2004-0137  
 Application I. D. Number  
 6/29/2004  
 Application Date  
 Boathouse/Guesthouse  
 Project Name/Description

July 13, 2004

RE: 328 Island Avenue, P.I. - 087-R-002 - IR-2 Zone - Shoreland Zoning - Floodplain

I am in receipt of your permit application to construct a new single family dwelling with boat storage underneath. Please note that your permit application has been denied because it does not meet the requirements of the City of Portland's Zoning Ordinance.

BOUNDARY SURVEY PLAN
334 ISLAND AVE PEAKS ISLAND, MAINE

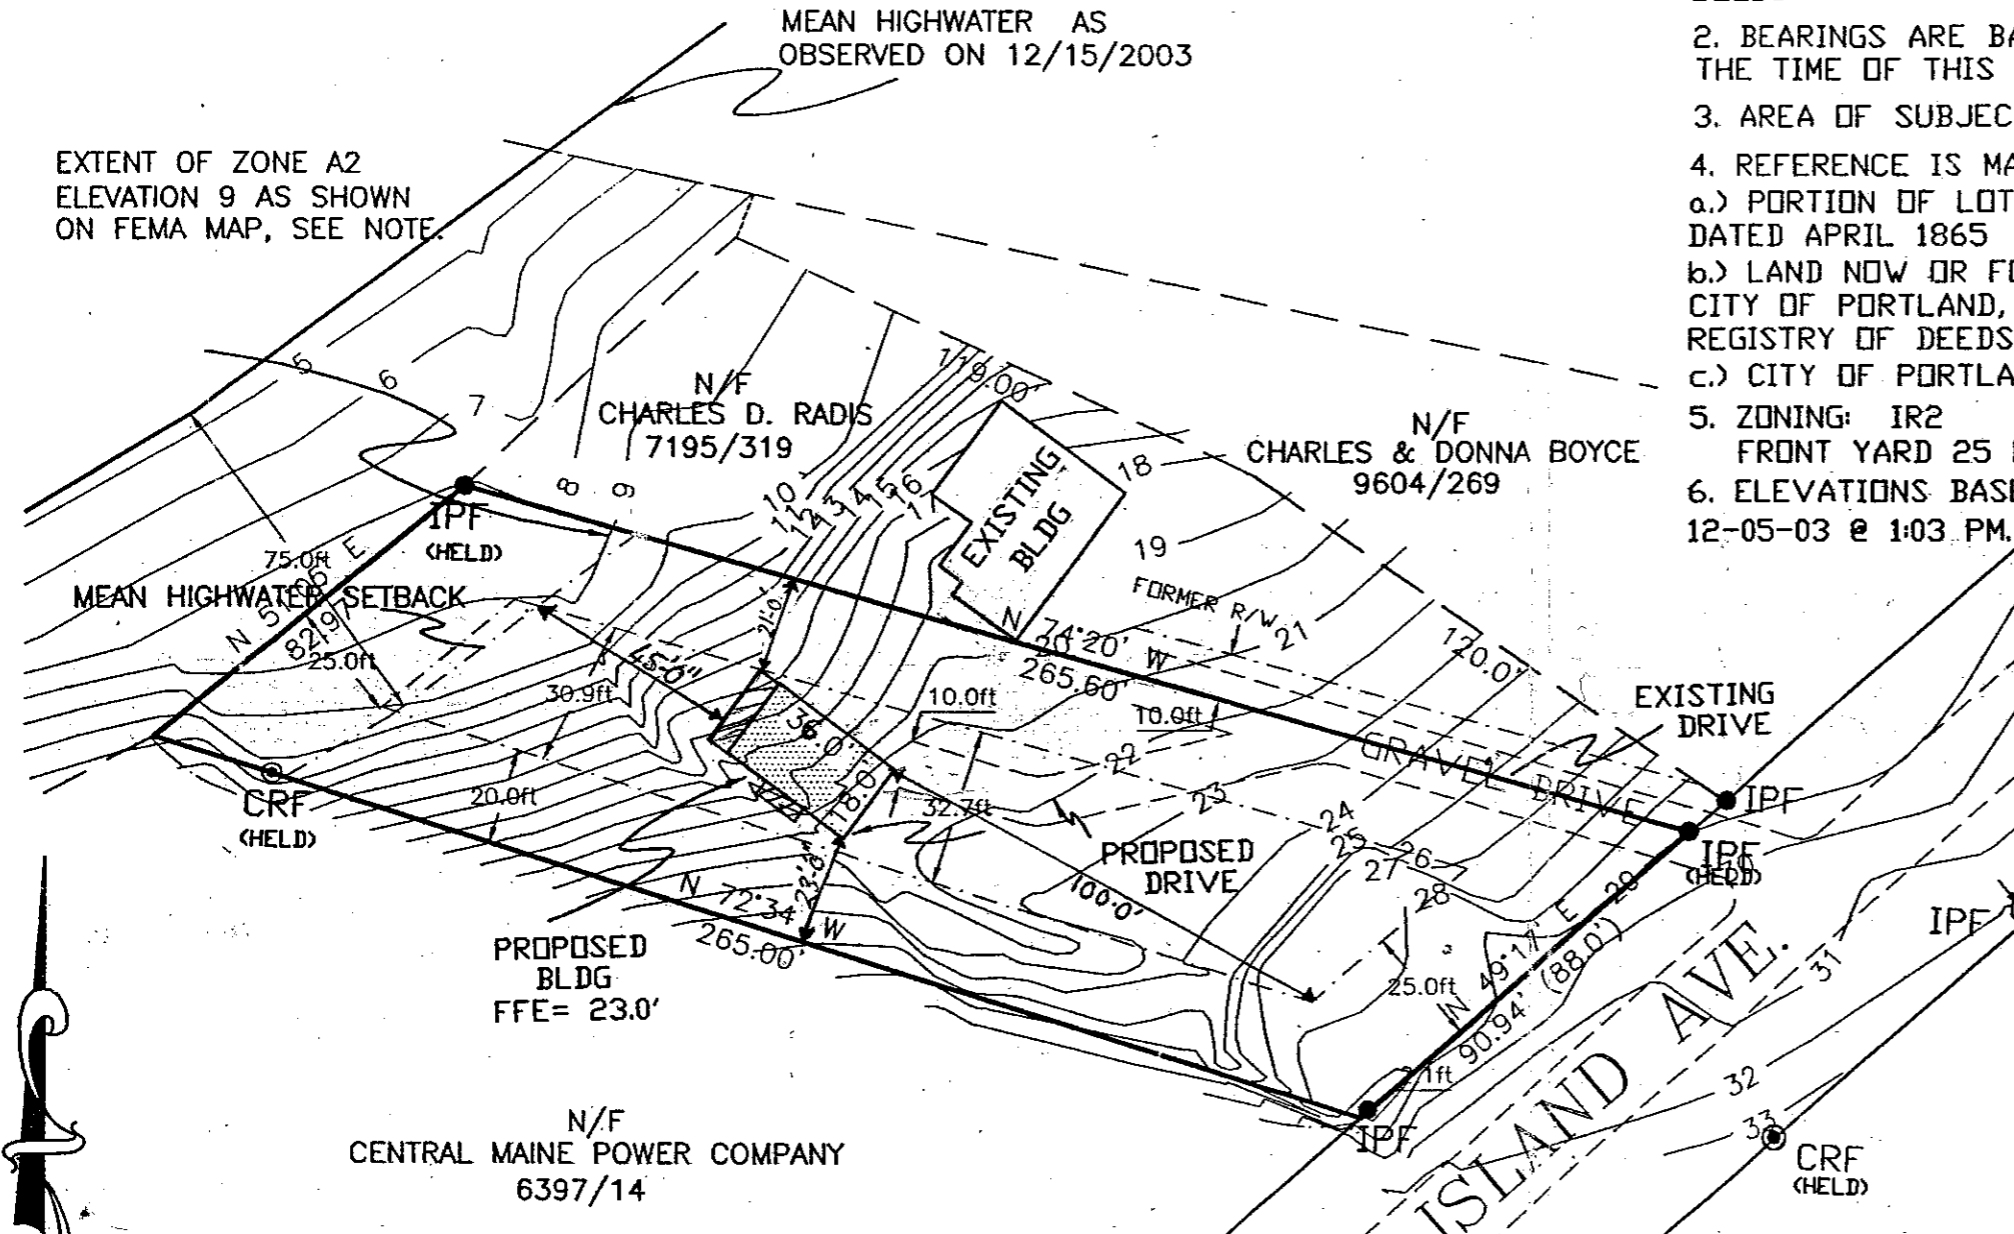
Section 14- 145.11 of the IR-2 zone requires a minimum lot size of 20,000 square feet. The Assessor's records show the lot size to be 18,683 square feet and the survey that you have submitted shows the lot to be 19,123.8 square feet. You have not supplied any information to show that this lot might be considered a lot of record and held under separate and distinct ownership for any adjoining lots since July 15, 1985.

This property is located within the Shoreland Zone area. Section 14-449 of the Zoning Ordinance requires structures to be setback a minimum of 75 feet from the high water mark, instead of the 45 feet from the mean high water mark that you have shown on your plans.

This property is located with the Flood plain area A2 with a given elevation of 9 as denoted on FEMA panel 15. 14-450.8 requires the lowest floor elevation to be a minimum of two feet above the given elevation of 9 feet. The lowest floor elevation by definition would be your boat storage area. Your plans are deficient in denoting what the lowest floor elevation is using N.G.V.D. It is your responsibility to verify and supply that information with your application.

Section 14-332 requires all new dwelling units to show two off-site parking spaces. None are shown on your submitted plans.

Section 14- 145.11 requires the maximum building height for a principal building to be no more than 35 feet from pre-development grade. This office has not been provided with any such

information. This office will require all predevelopment grades around the proposed house prior to any approvals.
